NUMBER: 2019/60/91609/W

Location: Adj, Marsh Conservative Club, Abb street, Marsh, Huddersfield, HD1 4PB

SITE PLAN  
1:200

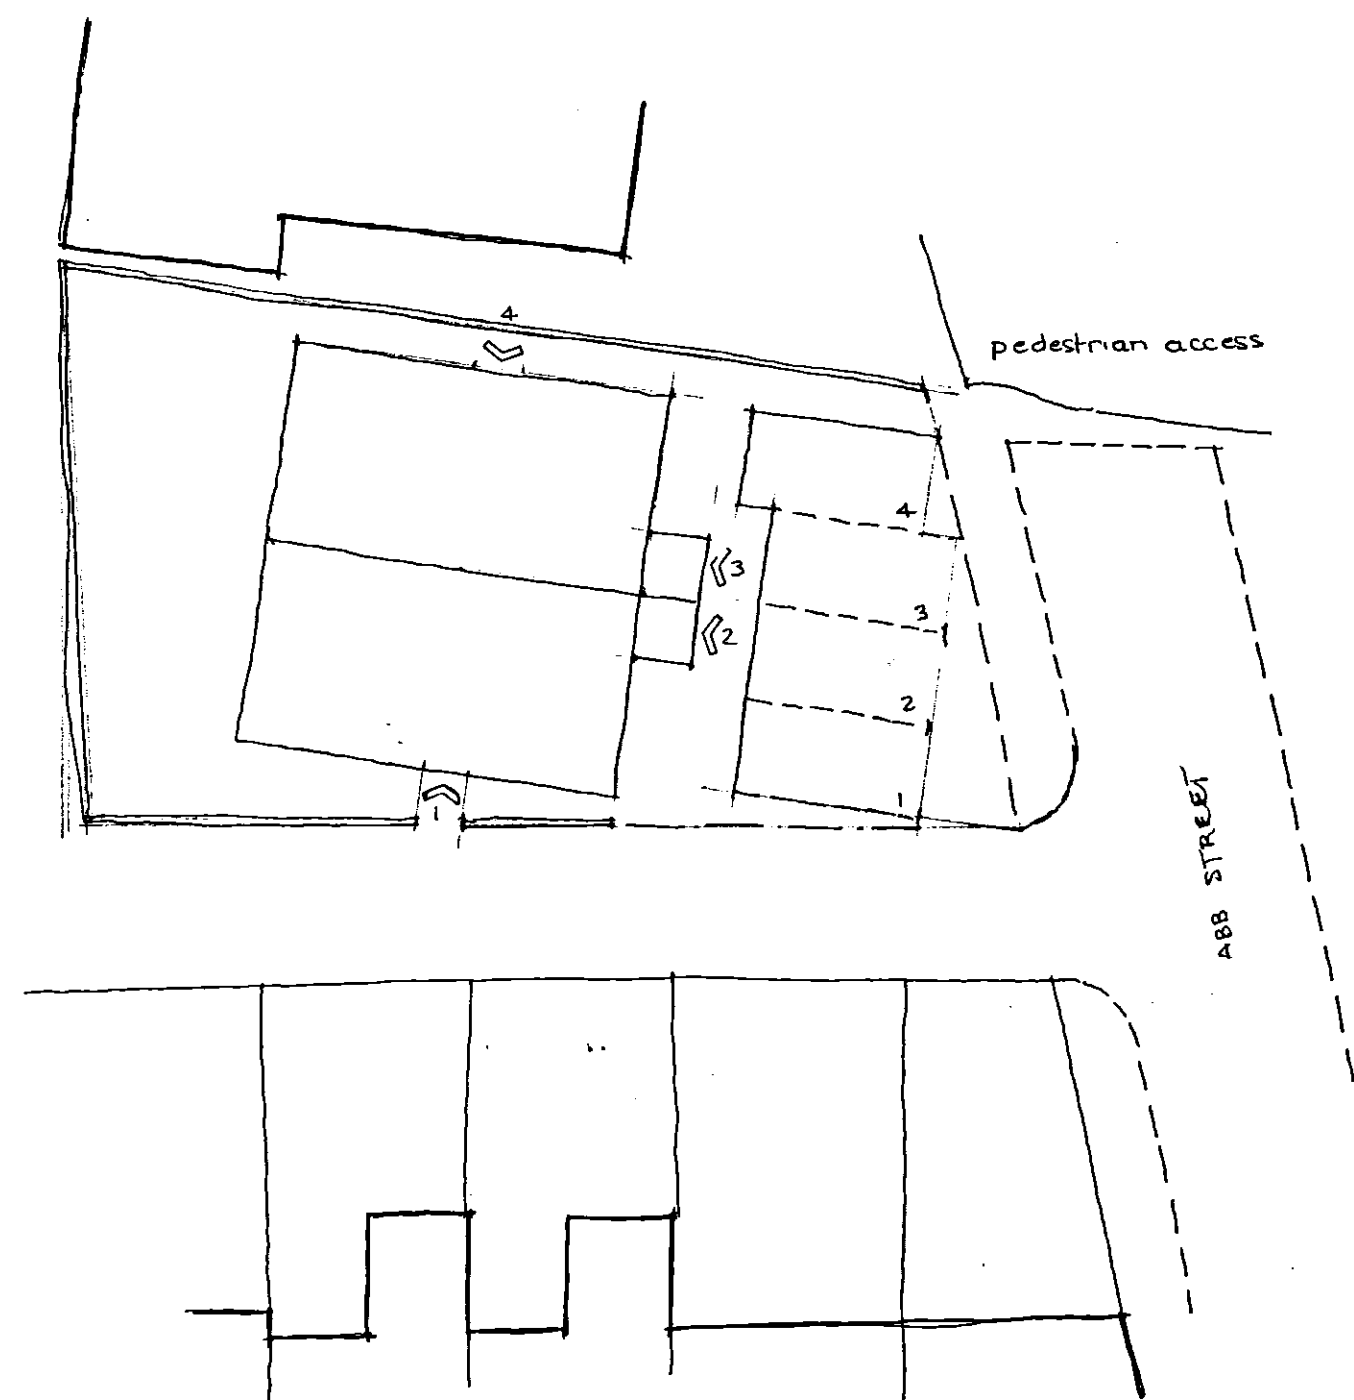
2. There is already a chronic lack of parking space of vehicles, nowhere to park, having to spill onto Croft House Ln, Colwyn Street, and Imperial Road. Whilst the plans accommodate for 4 additional spaces, this will not be enough to accommodate the flats, should they be occupied by a couple, or have guests over. This will put even more pressure on the area, where the Conservative Club can host events that sees parking pushed beyond its safe limits, with cars often boxed entirely in. The addition of more vehicles could hamper emergency access, with Abb Street already inaccessible for Fire engines or Ambulances when vehicles park near its entrance.

3. Planning also shows the loss of pavement on Abb street, which would lead to the loss of parking in the creation of the parking shown on the plan. This could also impact on how members of the public access the Con Club, where it acts as the primary access point.
